**WEST SUSSEX COUNTY COUNCIL  
STRATEGIC PLANNING CONSULTATION**

**SUBJECT:** A/82/12 - Residential development comprising 150 x dwellings including 30% affordable with access, landscaping, open space & associated works (this application is a Departure from the Development Plan).

**LOCATION:** Land East Of, Roundstone Lane, Angmering, West Sussex, BN16 4AL

This is the second WSCC Highways and Transport response to the planning application and follows comments made on 6<sup>th</sup> September 2012. It should be read alongside that earlier document.

Appendix 2
Roundstone Lane Roundabout Plan
and Photographs

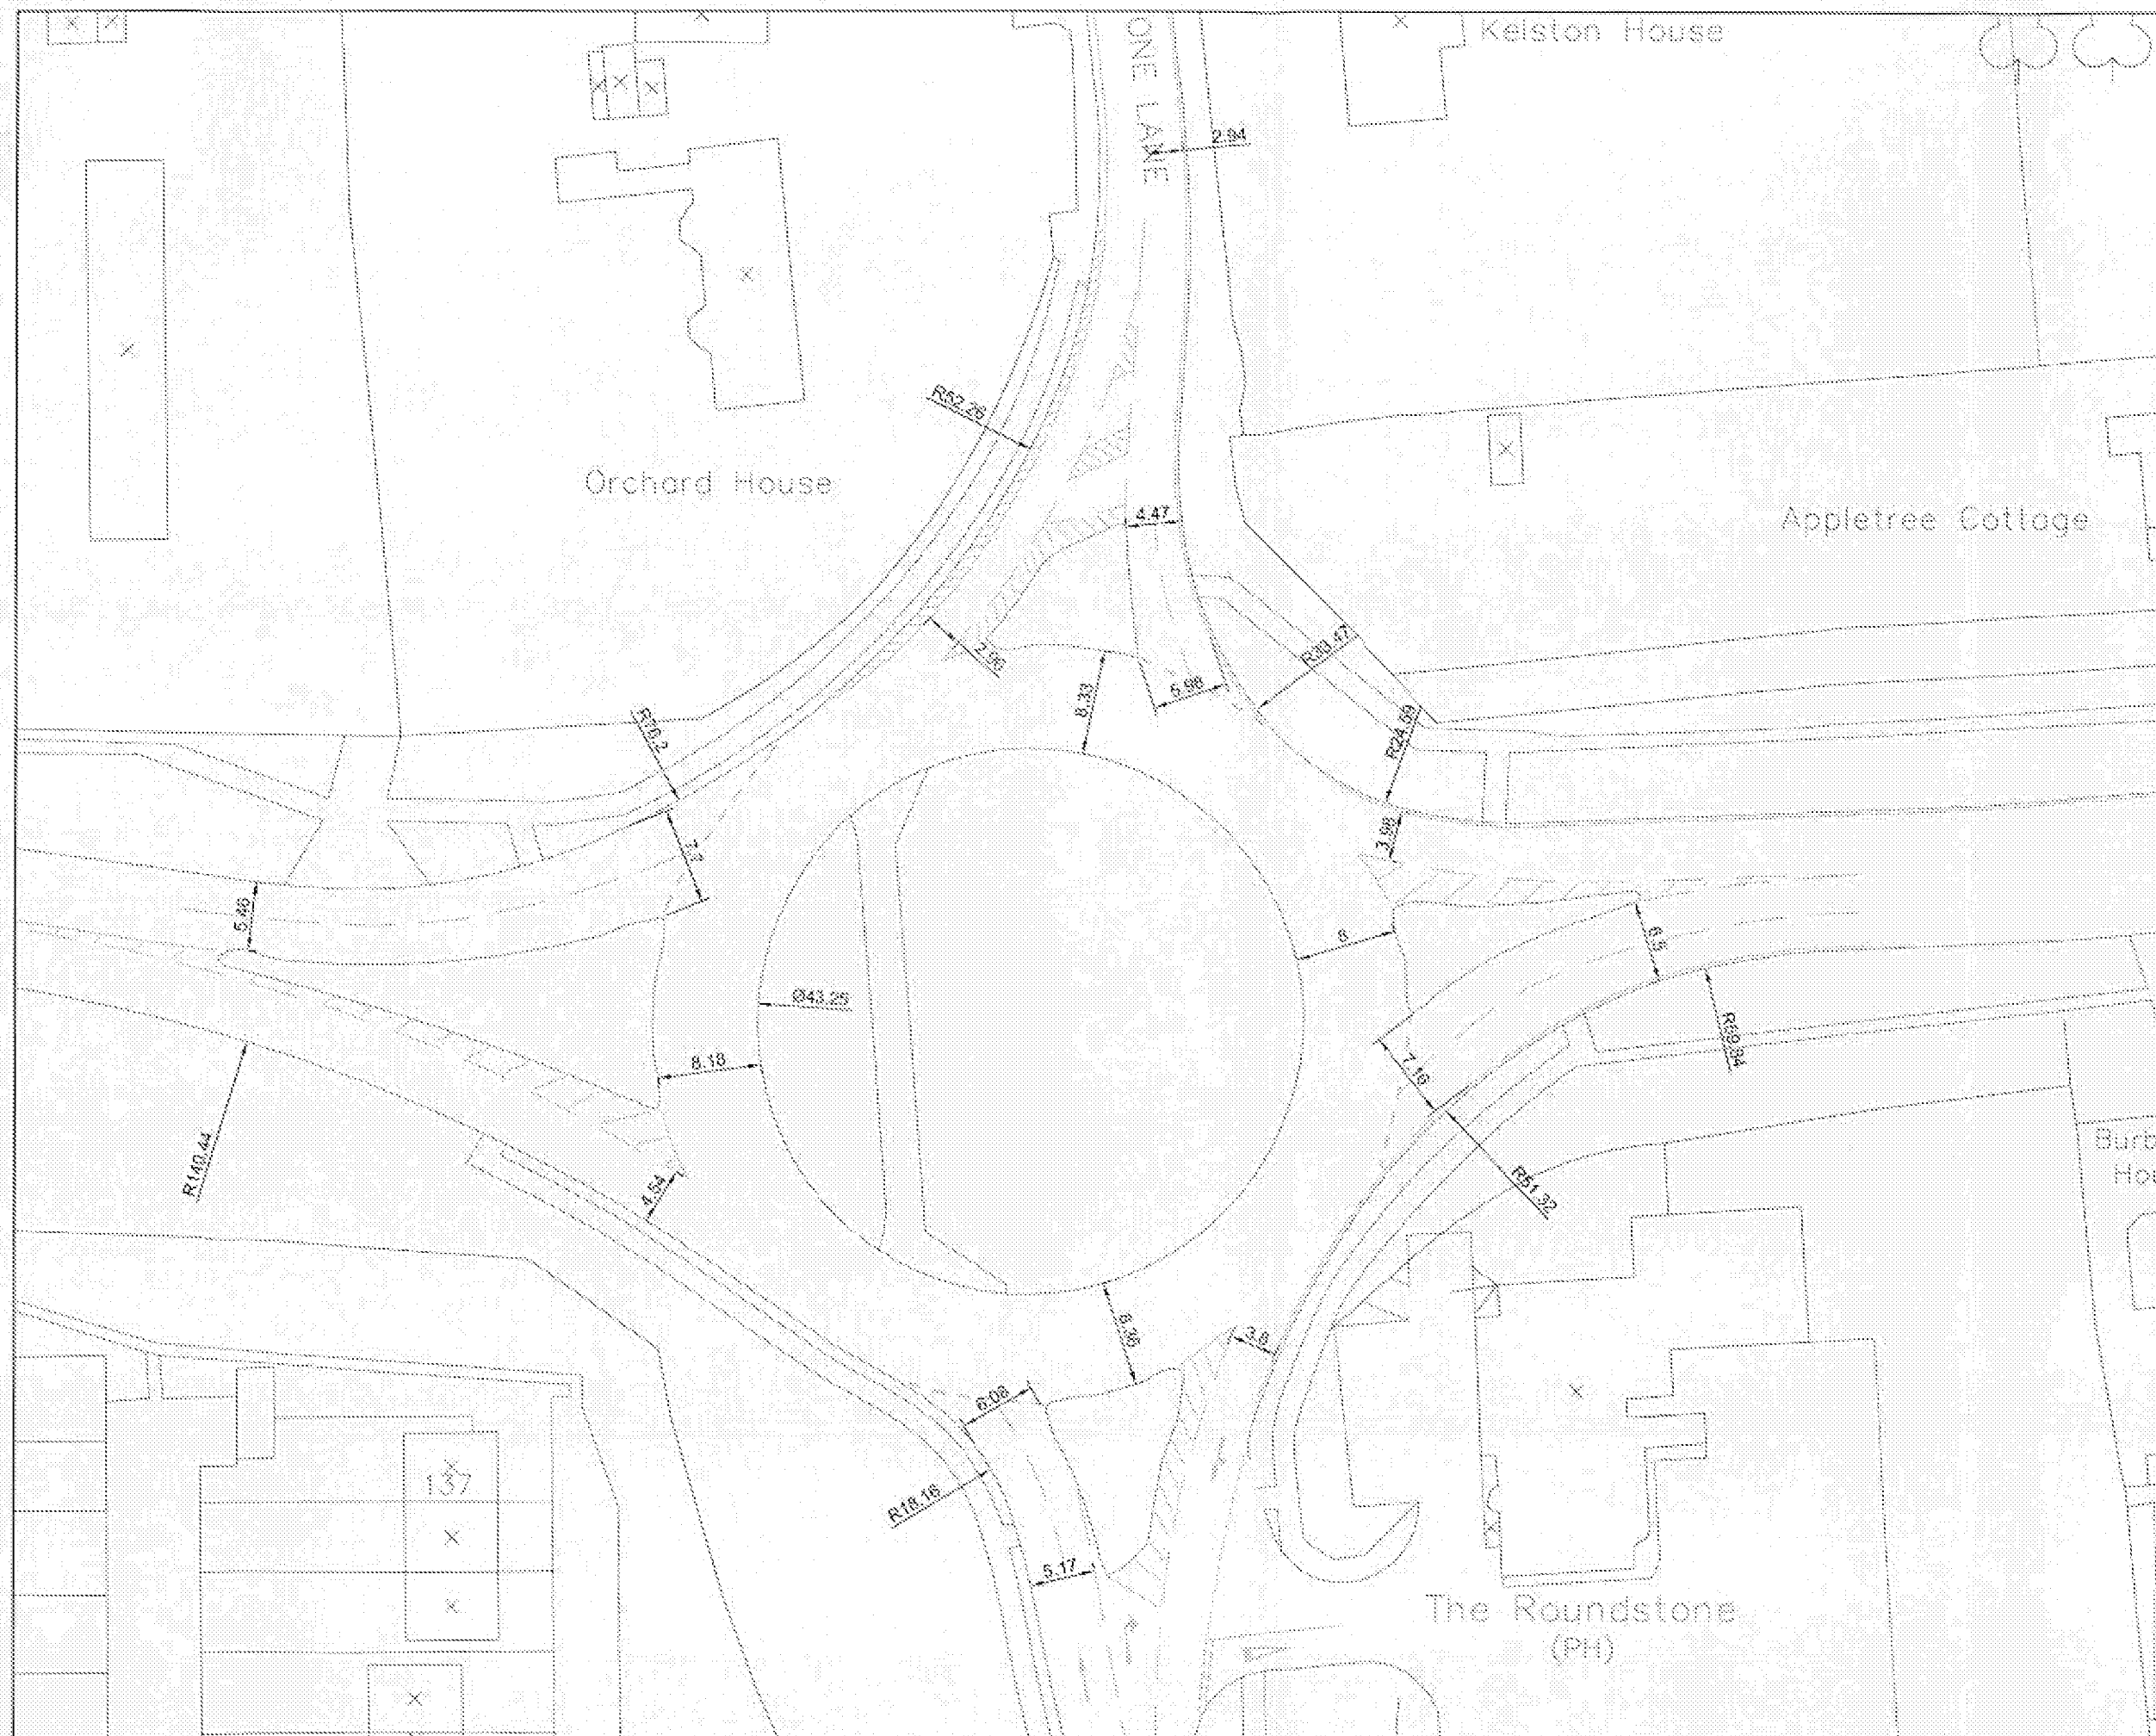
The junction of the A259 with Roundstone Lane appears to have a narrow exit arm from Roundstone Lane which appears to reduce capacity on the arm, particularly when large vehicles attempt to leave Roundstone Lane to join the A259. Some overriding of the grass verge on the nearside of the northern arm is evident in the form of tyre track markings. Further information has been provided by the applicant's highway consultant, including a video survey on the junction functioning in the peak periods. On-site observation (during the am peak period on 27<sup>th</sup> November 2012 by the Highway Authority) revealed a maximum queue on the northern arm of Roundstone Lane of approximately 9 No. vehicles, albeit brought about because a coach was observed straddling the white lines at the junction. Average queues observed by the Highway Authority were approximately 4 vehicles during the am peak which is higher than the recordings in Appendix 1 of the aforementioned Technical Report of 23<sup>rd</sup> November 2012. Vehicles were observed getting away from the junction relatively quickly as gaps on the roundabout became available regularly.

Turning to the surveys and the revised ARCADY assessments provided in the Technical Report, some discrepancies were found, particularly with the ARCADY reports for the Roundstone Lane/Littlehampton Road (A259). In particular, the dimensions inputted to the ARCADY programme were different to those set out on Drawing No. 110 produced by the consultant. This should be corrected and the ARCADY re-run for this junction. Furthermore, drawings should also be provided for the A280/Littlehampton Road (A259) and Station Road/Littlehampton Road junctions with ARCADY re-run for these junctions, in order that the Highway Authority can check these as well.
